Submissions Report

STATE SIGNIFICANT DEVELOPMENT SSD-6026

Milk Processing Facility

111-113 Quarry Road, Erskine Park

Photo Log of Creek Survey undertaken on 25/7/13

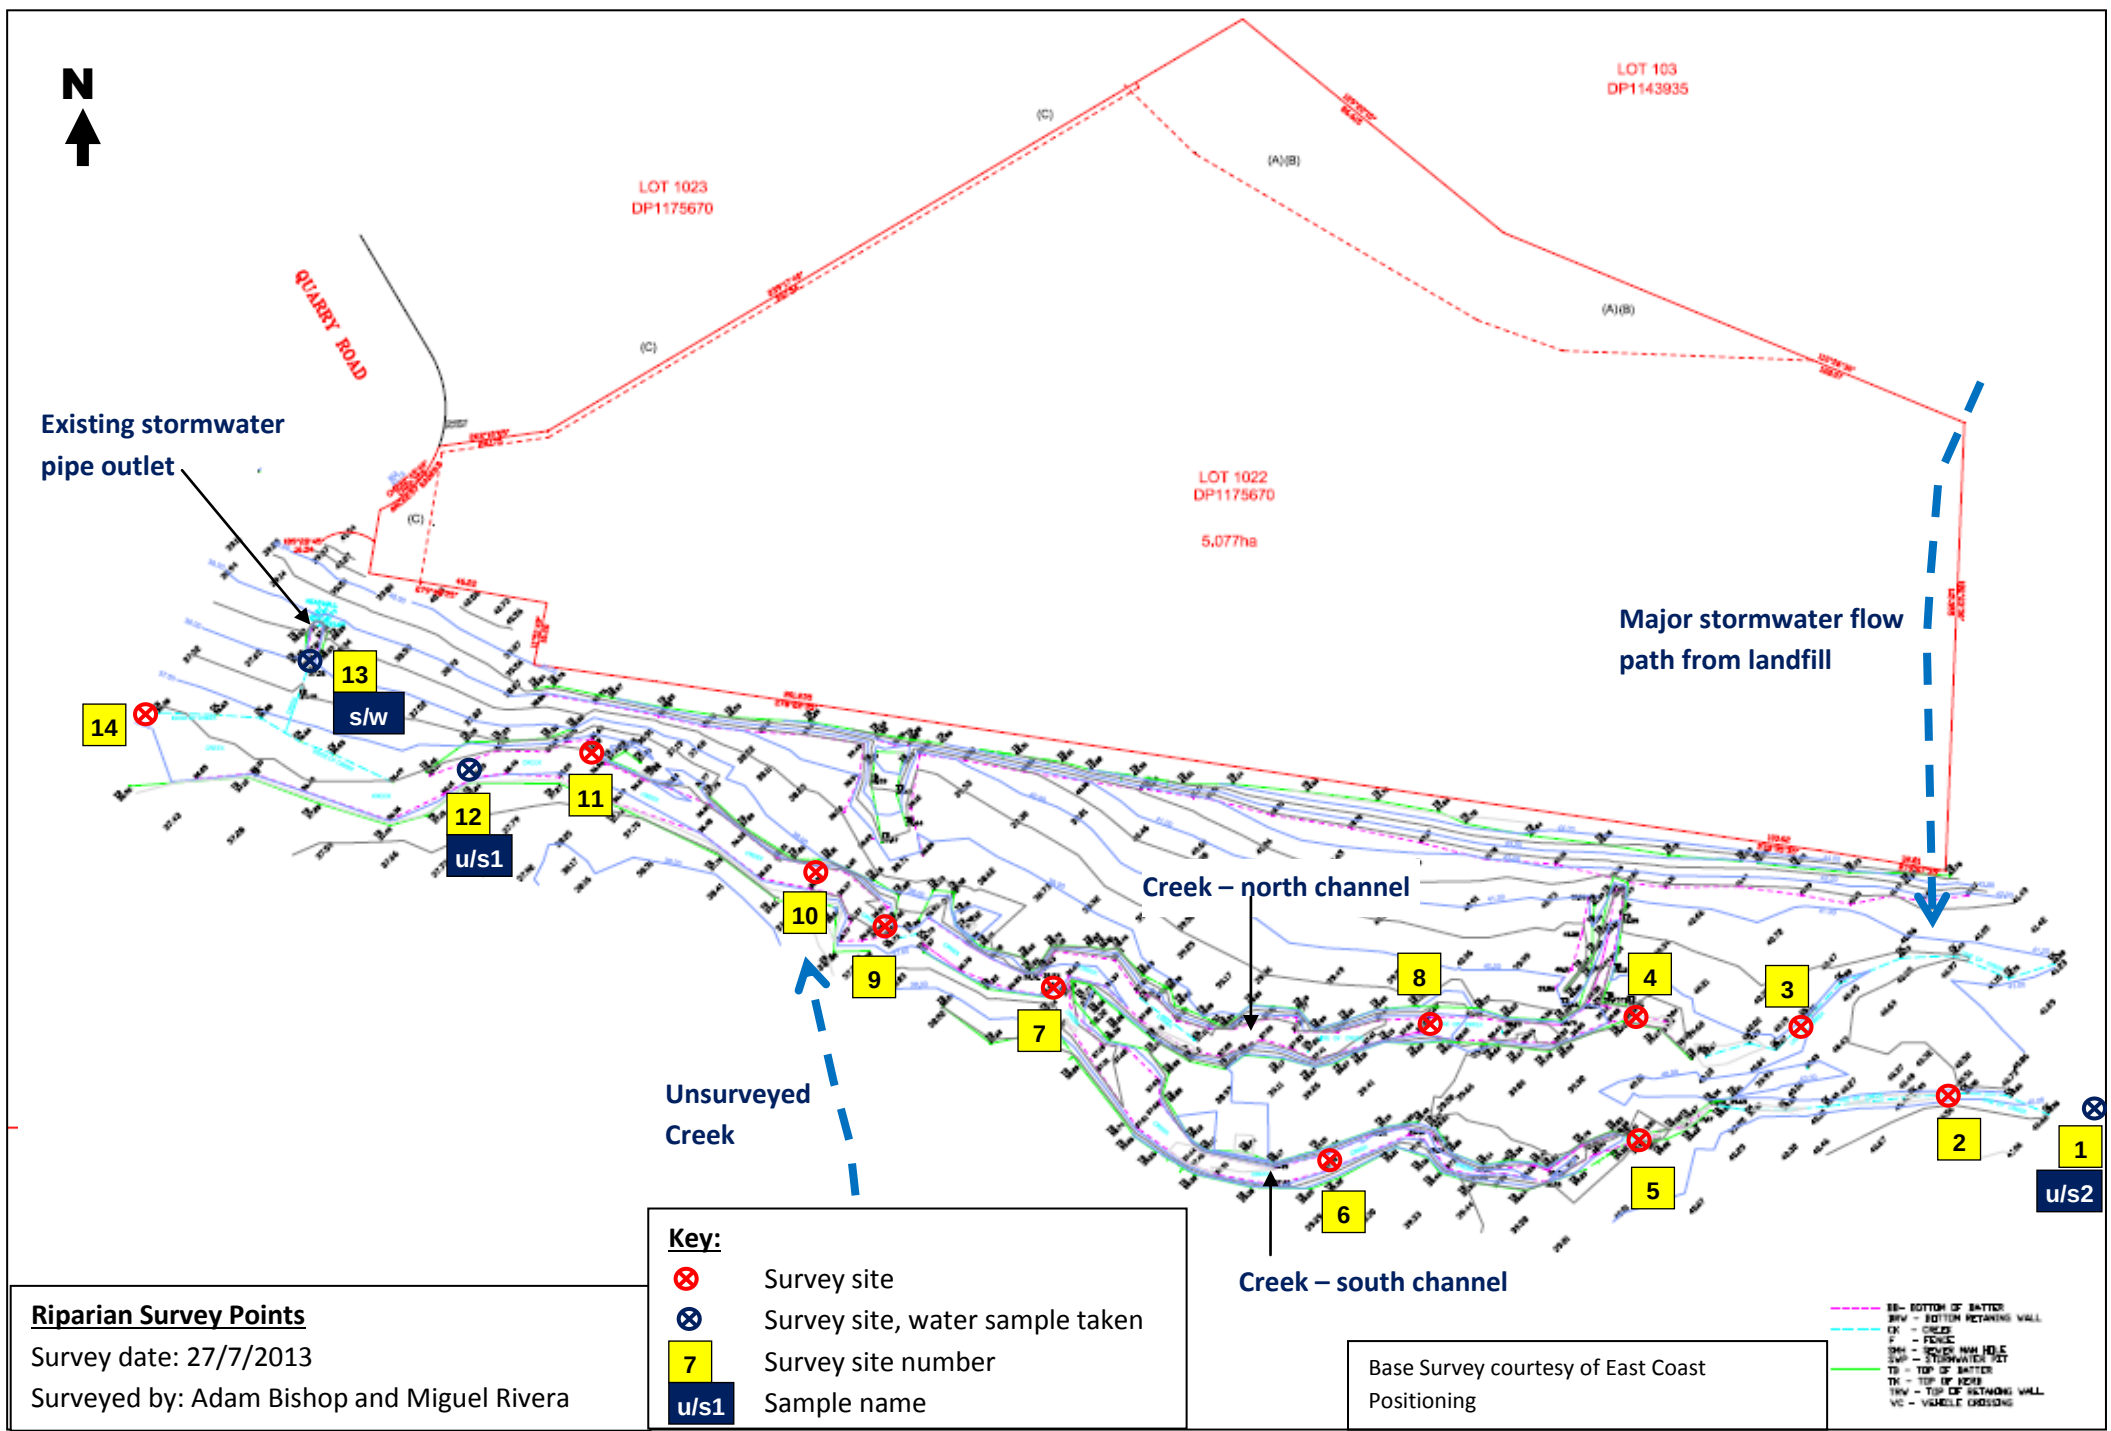
| Issues | Responses |
|--|--|
| <p>Appendix 3 of Technical Paper TP3 notes the stormwater outlet location is within cleared lands and River-Flat Eucalypt Forest (page 34). The Office of Water recommends the following:</p> <ul style="list-style-type: none"> The stormwater outlet structure placed to avoid disturbing remnant native vegetation. A scaled plan, which shows the location of: <ul style="list-style-type: none"> The proposed stormwater structure route. The creek and top of the bank. The boundary of the Biodiversity Corridor. Remnant vegetation potentially affected by the outlet structure. | <p>The preferred stormwater discharge option involves connection to the existing Council drainage network and would involve no disturbance or activities in waterfront land (refer to Appendix 2). Council is yet to authorize this option, so the fallback option is to construct a new outlet.</p> <p>The new outlet structure would be located near the existing Council outlet and would involve only minimal clearing of native vegetation within the River Flat Eucalypt Forest, as shown in Appendix 3. The vegetation likely to be disturbed is relatively young regrowth. The new outlet structure would be primarily located in a grass strip area as shown in Appendix 3.</p> <p>Appendix 2 indicates the stormwater structure route and the boundary of the biodiversity corridor. The impact on remnant vegetation is described above and illustrated in Appendix 3. Appendix 4 provides a survey of the creek.</p> |

DETAIL
1:400

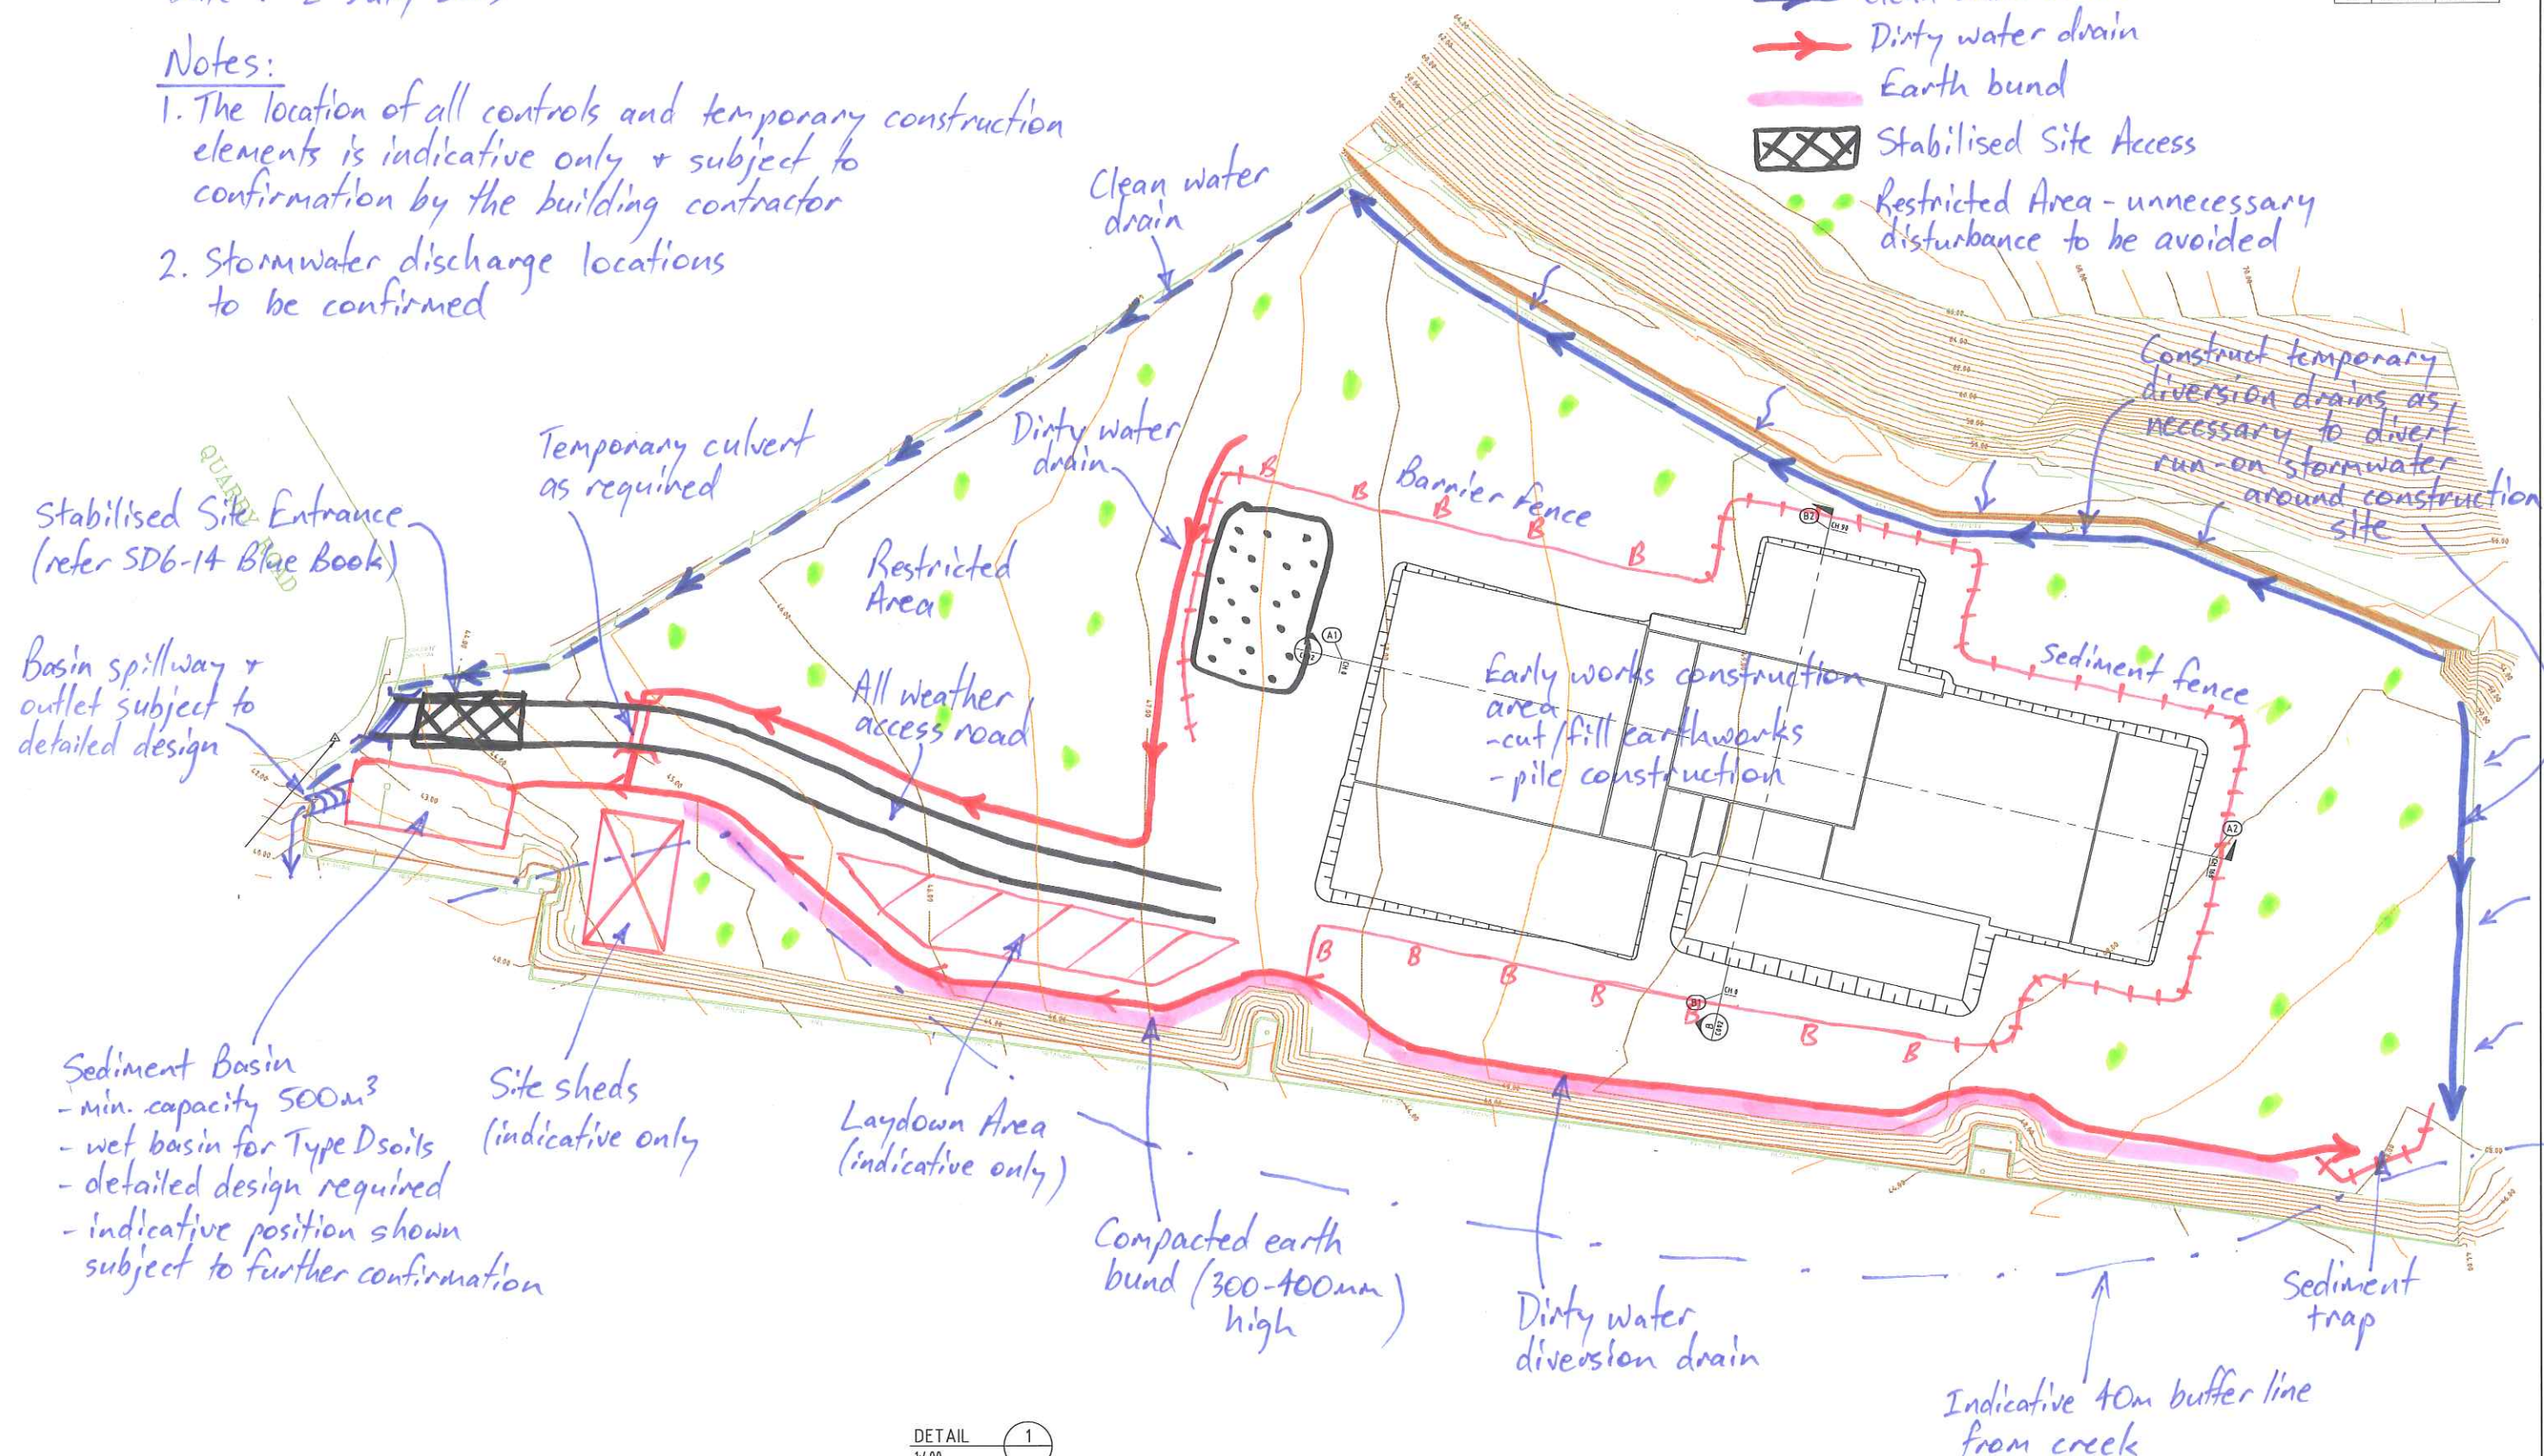
| Issues | Responses |
|--|--|
| <p>The Office of Water agrees that the works should be designed to discharge stormwater in suitable locations at non-erosive velocities that will not cause damage to the receiving environment. As far as practicable, the works should be kept outside the 40m buffer surrounding the creek.</p> | <p>The new stormwater outlet (if required) would be located near the existing outlet. This is the preferred location as it takes advantage of the very low grades in the area, which will help control flow velocity at the outlet and benefit long term stability. This location also minimizes the need for vegetation disturbance. Works within the 40m buffer from the creek would be limited to the minimum necessary to construct a stable outlet.</p> |
